City of Albuquerque

RE: REVISED DRAINAGE PLAN FOR PRESBYTERIAN WAREHOUSE ADDITION (J-14/D68A)
REVISION DATED AUGUST 25, 1992

PROJECT TITLE PRESBYTERIAN WAREHOUSE ADD'N ZONE ATLAS/DRNG. FILE #: J-14-Z

C102	GRADING AND DRAINAGE PLAN
1"=20'-0"

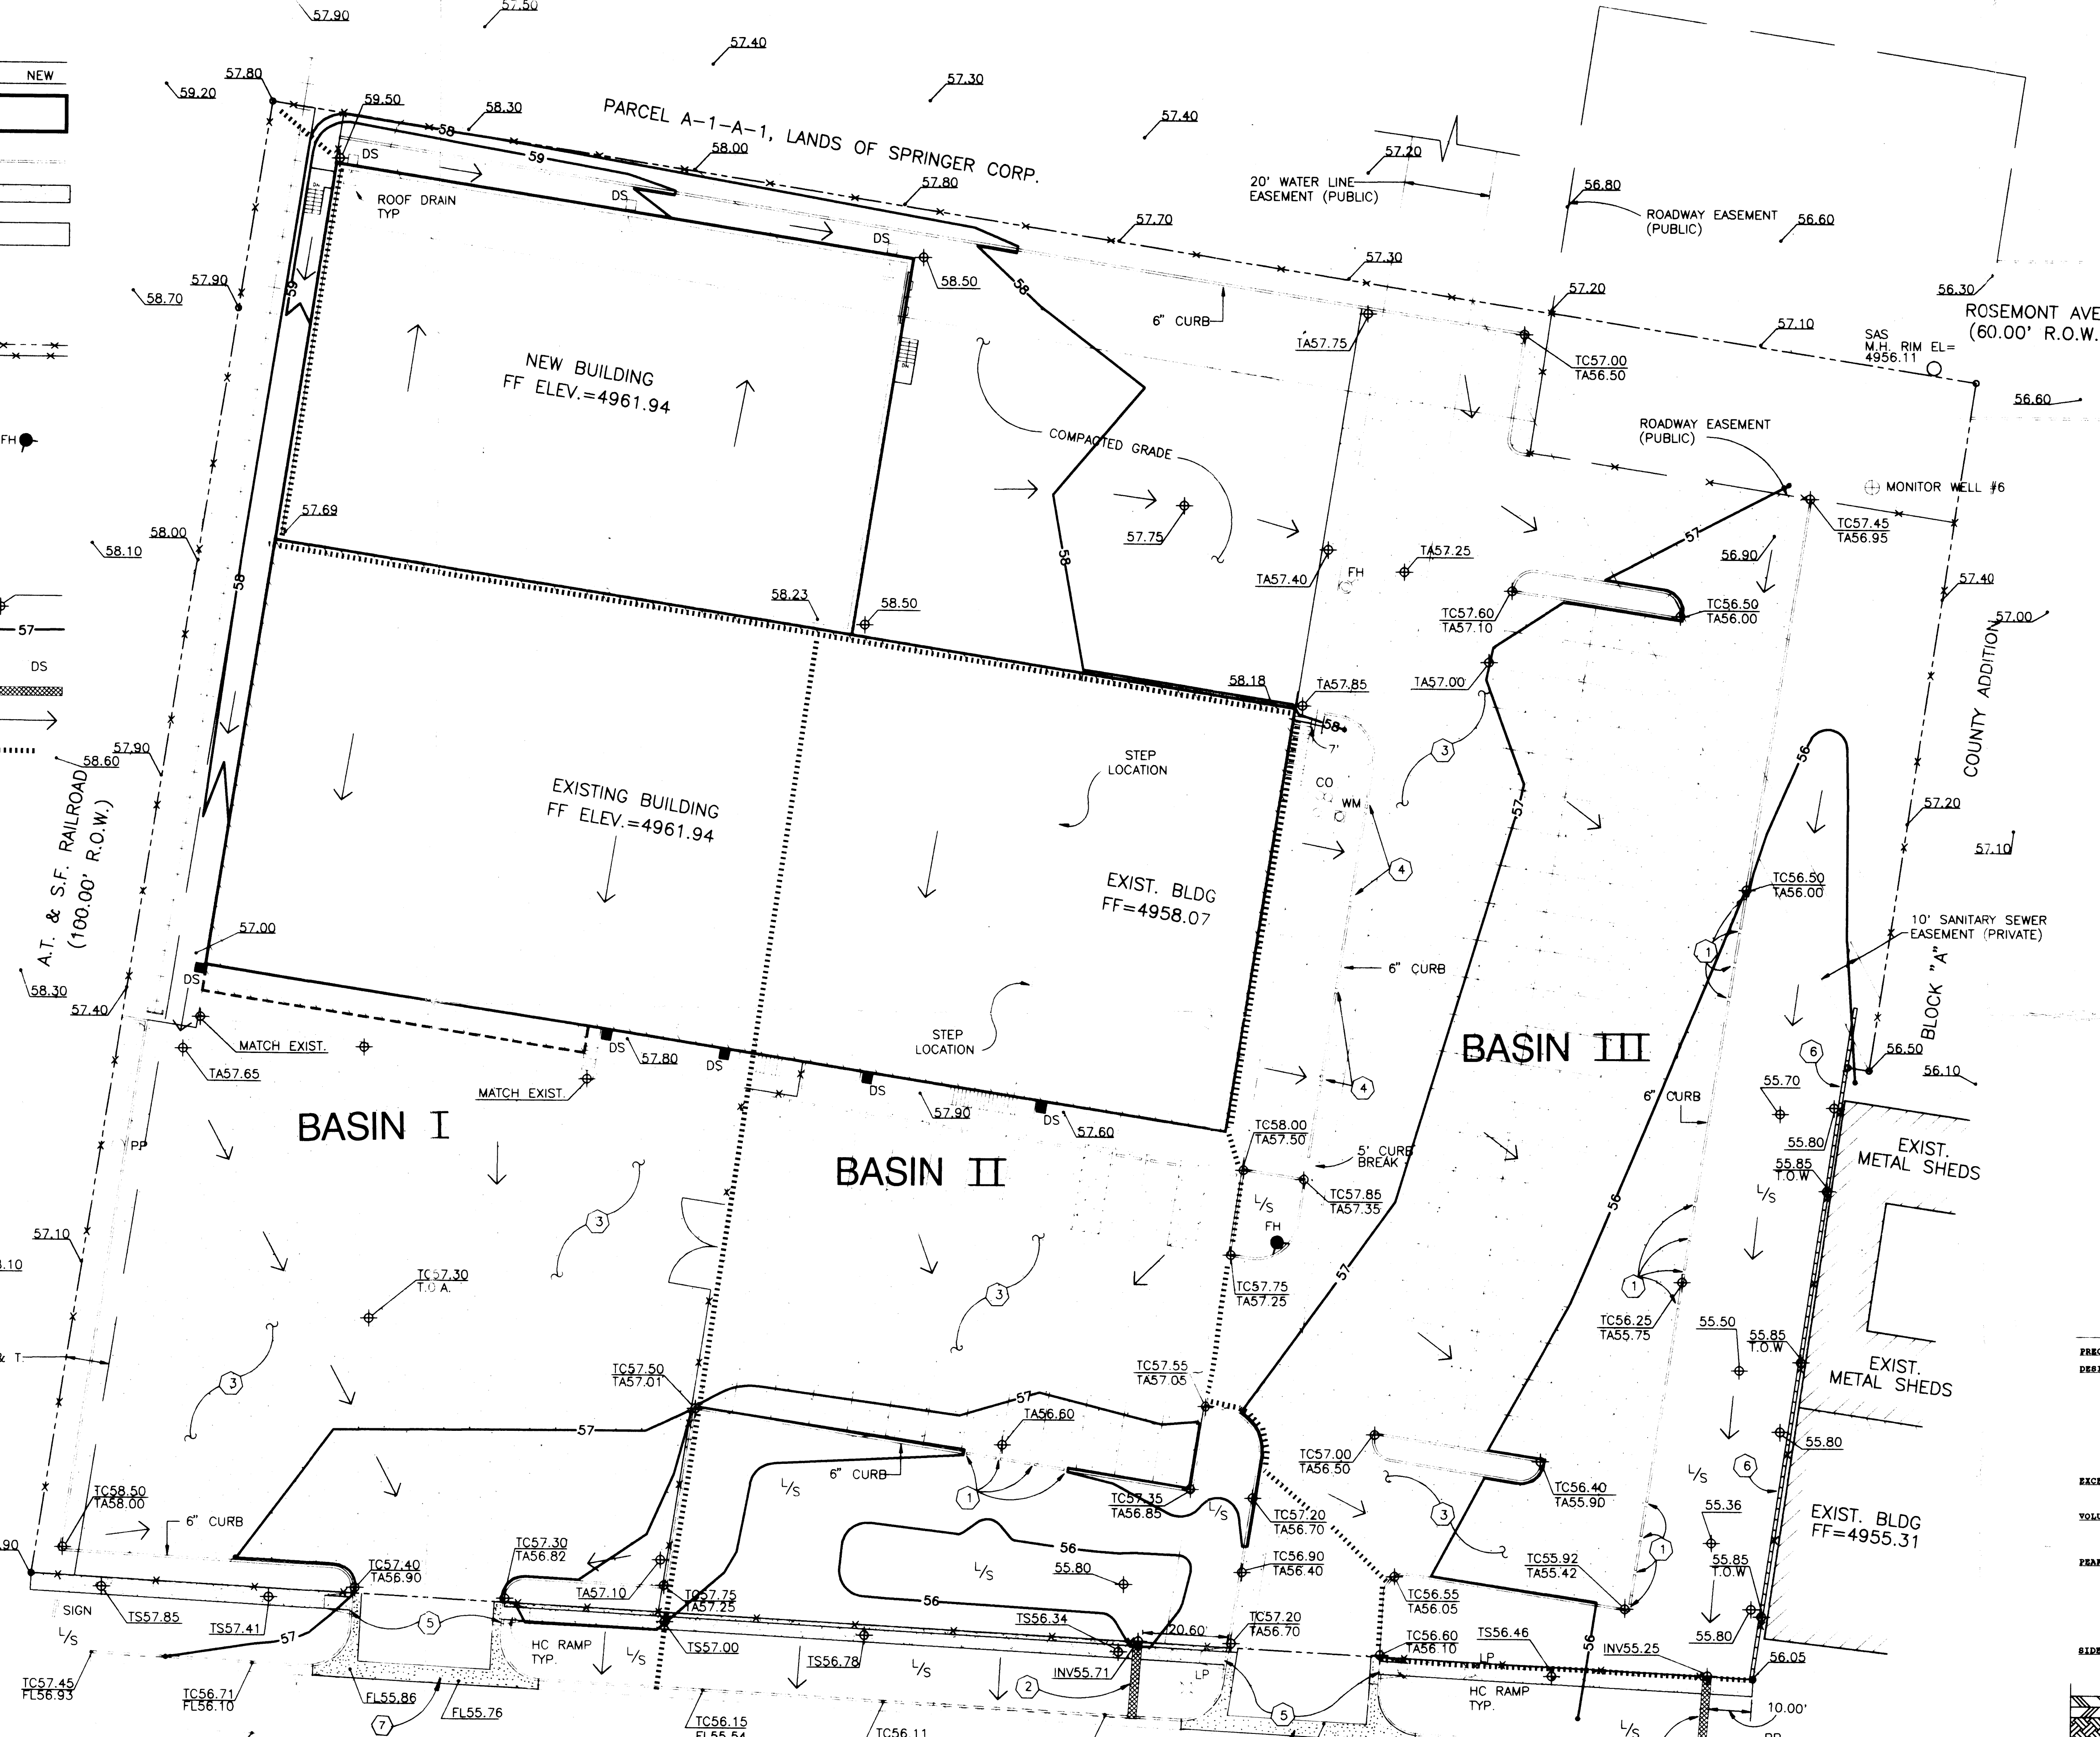
- ✓ 1. Identify what basins are going to each proposed sidewalk culvert and also provide the hydraulics for the culverts.
- ✓ 2. Sign-off block for the S.O. #19 format along with the six notes within the plan drawing.
- ✓ 3. Sidewalk culvert specs do not allow you to sawcut the face of the curb, you must remove the complete stone. Please remove that note from the plan drawing about the sawcut.
- ✓ 4. Two (2) copies of blueprints are required with your resubmittal.
- ✓ 5. Evaluation of your determination for free discharge onto Mountain Road.
INLET IN BROADWAY?
